Rezoning Transportation Analysis

Petition Number: 2021-169

From: Brandon Brezeale, PE
Brandon.Brezeale@charlottenc.gov
704-432-5561

Date	Description
11-19-2021	First Review (KP)

JOB NO.	99999
SHEET NO.	RZ-100

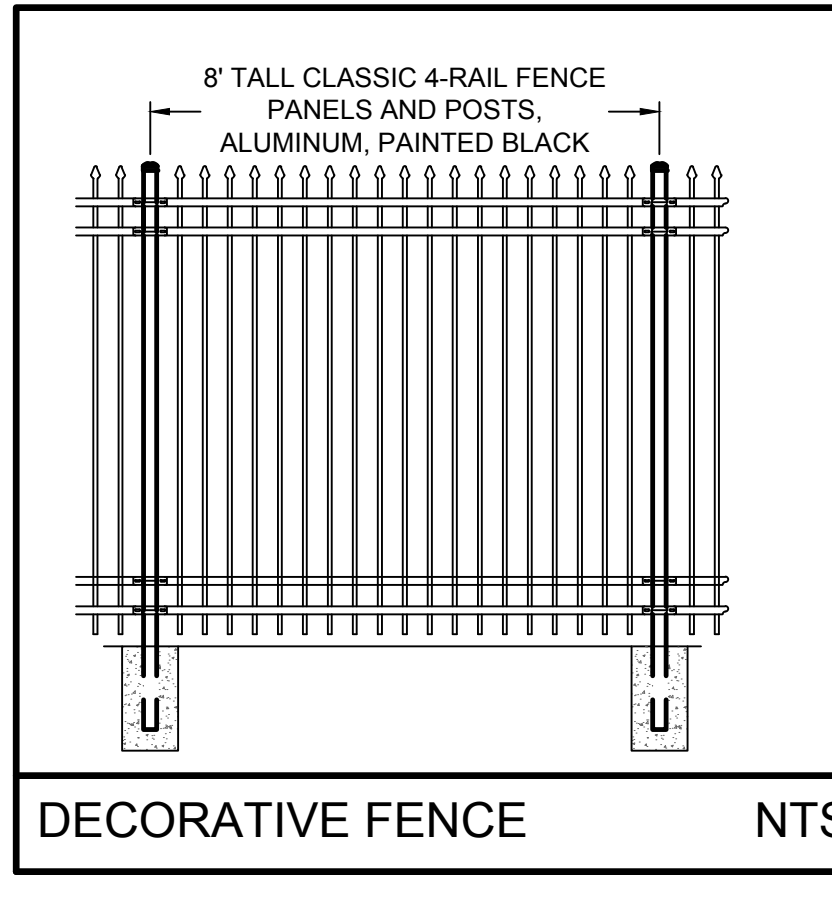
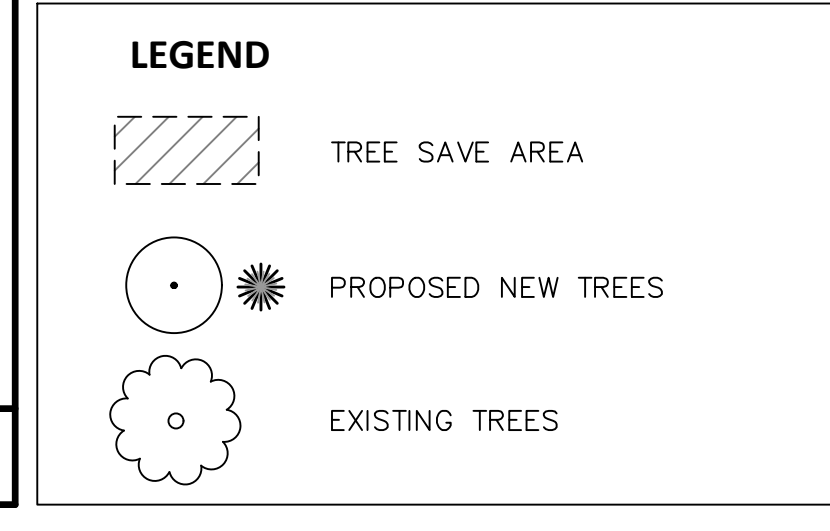
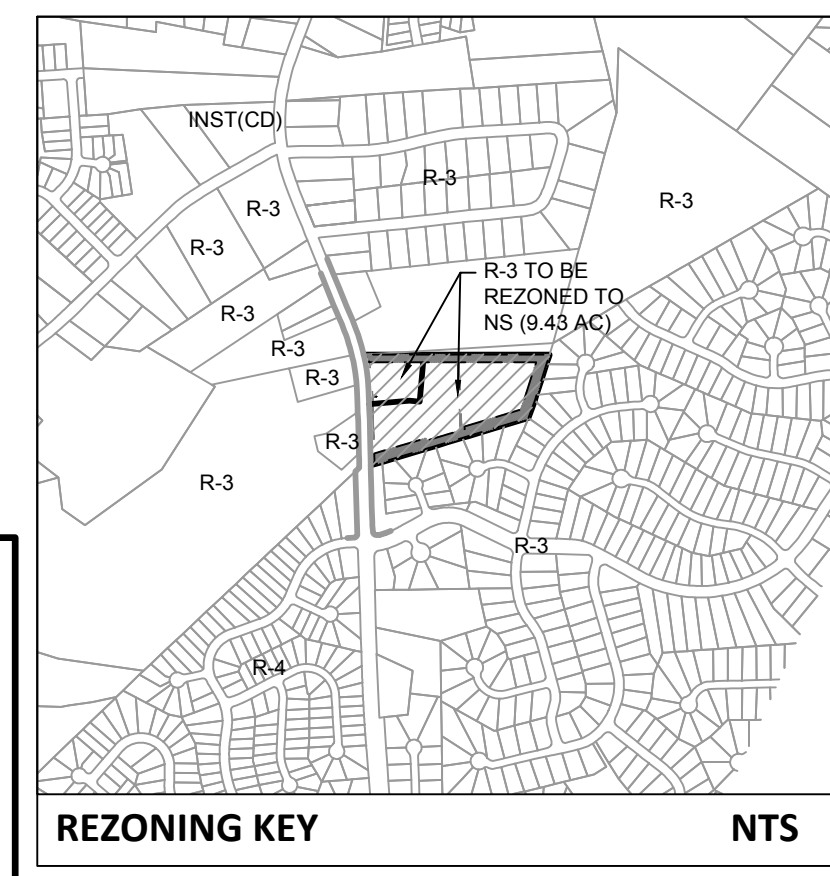
1. Curb line:

- a. **Mount Holly-Huntersville Road:** The location of back-of-curb and gutter shall be placed 30-feet from the existing road centerline.

Label and dimension the curb and gutter from the centerline to the back-of-curb.

3. Revise site plan and conditional note(s) to commit to dedicate 52-feet of right-of-way from the existing centerline of Mount Holly-Huntersville Road. The site plan shall label and dimension the right-of-way from the road centerline.

4. Revise the conditional notes by committing to construct the left-turn lane and right-turn lane into the site as generally depicted on the site plan. Additionally, commit to coordinate with NCDOT, during permitting, to determine the appropriate storage and taper lengths for each turn lane.

5. Revise the site plan by clarifying the limits of Development Area B.
